CITY OF ALBUQUERQUE

October 5, 2017

RE: **Industrial Water Engineering**
Conceptual Grading and Drainage Plan
Engineer's Stamp Date 9/26/17
Hydrology File: C16D006LL

SHEET NO.
 CG-501

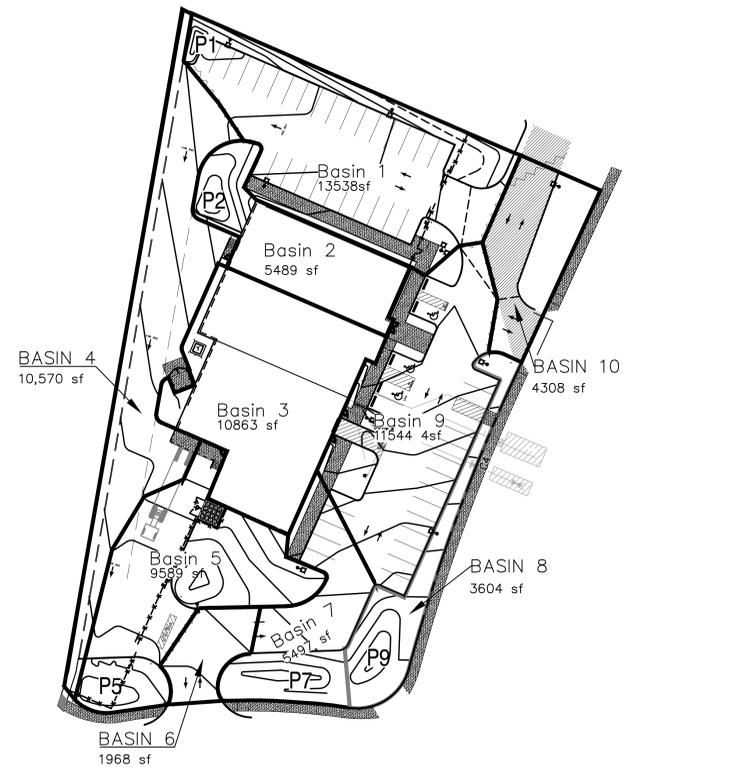
1. Payment of Fee-in-Lieu may be made at Building Permit. However, the bypass volume must be calculated and stated on the Conceptual Grading and Drainage Plan prior to DRB action.
